CITY OF ALBUQUERQUE

RE: Silver Oak Estates | Grading and Drainage Plan | Stamp 10-21-15 (File: C18D101)

Project Title: SILVER OAK SUBDIVISION

21525-LAYOUT-9-28-15

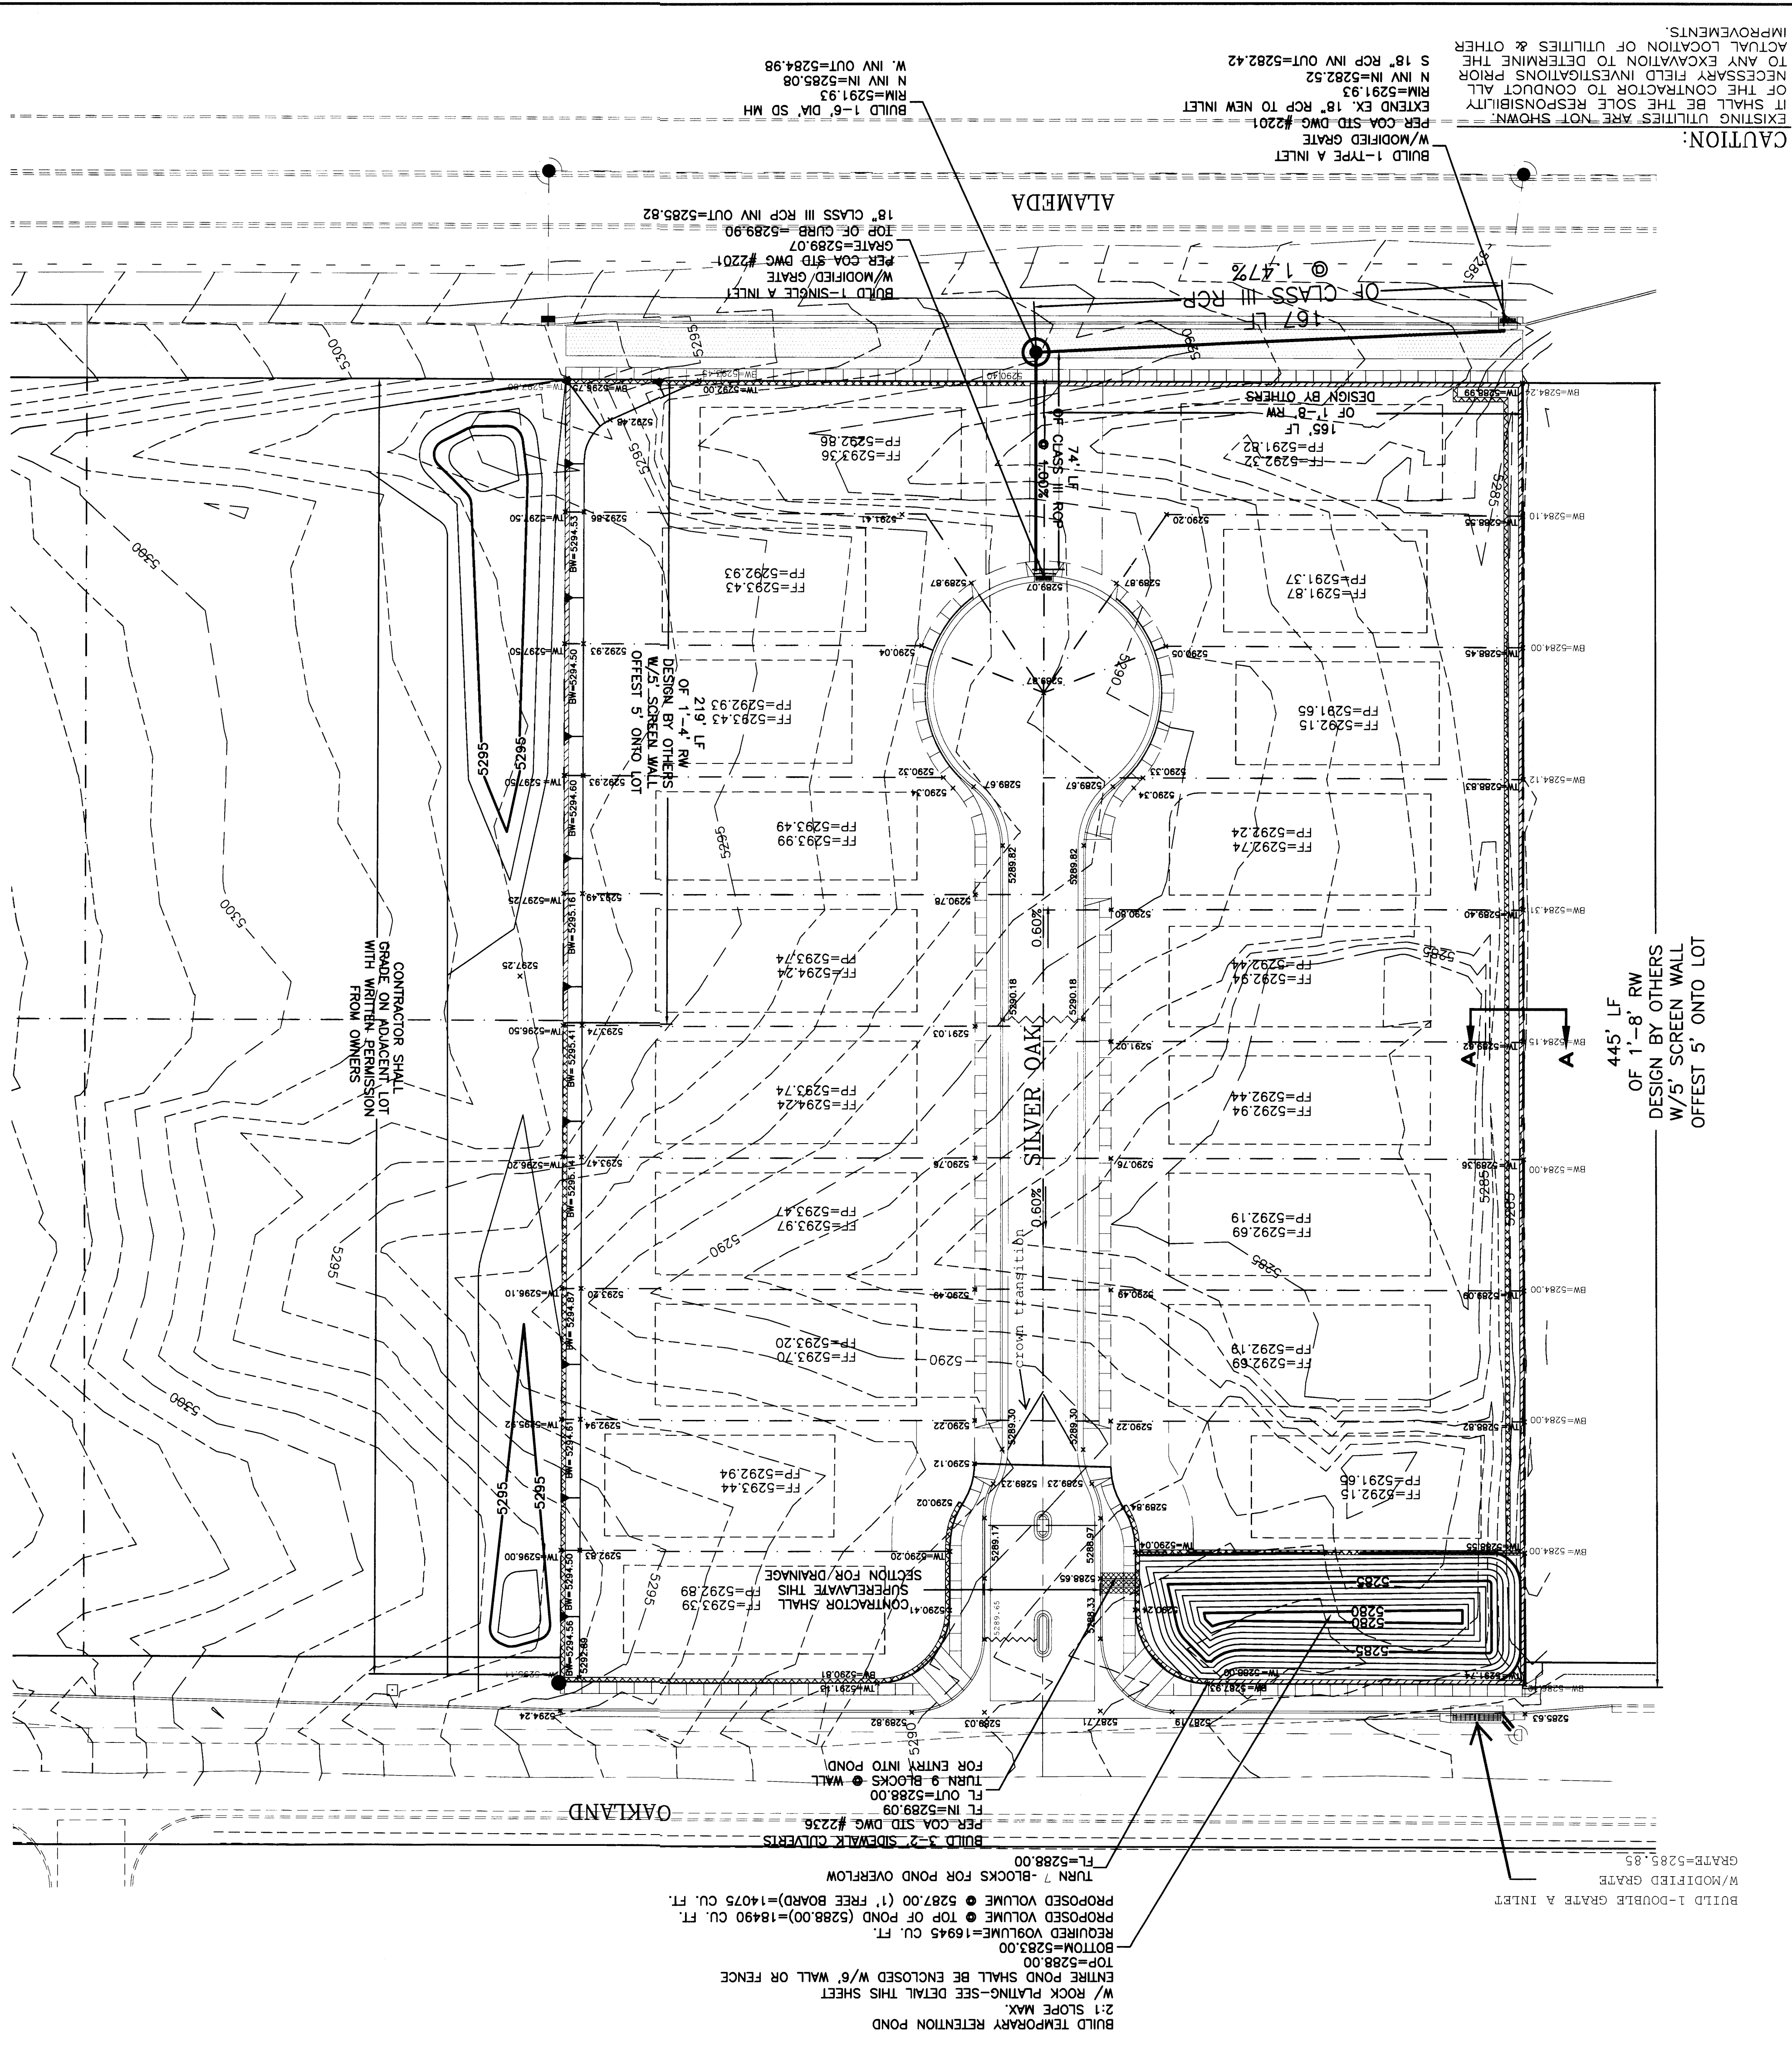
1. Clarify the easement dimensions between the cul-de-sac and Alameda Blvd. The Utility Plan shows a different layout than the Site/Grading Plan.
2. The inlet at the end of the cul-de-sac bulb appears to conflict with the intent to have an access easement to the southernmost lots.

3. At the entrance, there is a low spot on the northbound side curb and gutter; it appears that the intent is to convey flows west into the temporary pond. The plan should clarify to the Contractor that the crown of the road is to be warped so as not to create a sump.

4. The inlets on Oakland and Alameda should have build notes
 - a. The inlet on Alameda is referenced as a single grate Type D inlet to capture flows at the flowline of the roadside swale, but shown differently on the plan. Furthermore, this inlet and pipe needs to be planned with the future expanded section of Alameda Blvd in mind.

5. Show the emergency spillway for the pond as referenced in the drainage report.
6. Call out the wall opening that will be needed to convey flows into the pond.

7. Show elevation points at the rear lots that show the intent to install rear lot ponds.
 - a. The rear and front yard ponds and typical lot layout showing the first flush ponds should also be shown on the landscaping sheets, since it appears that the fine grading of those facilities might be completed with the installation of graveling and plantings, not with the grading of the lots.
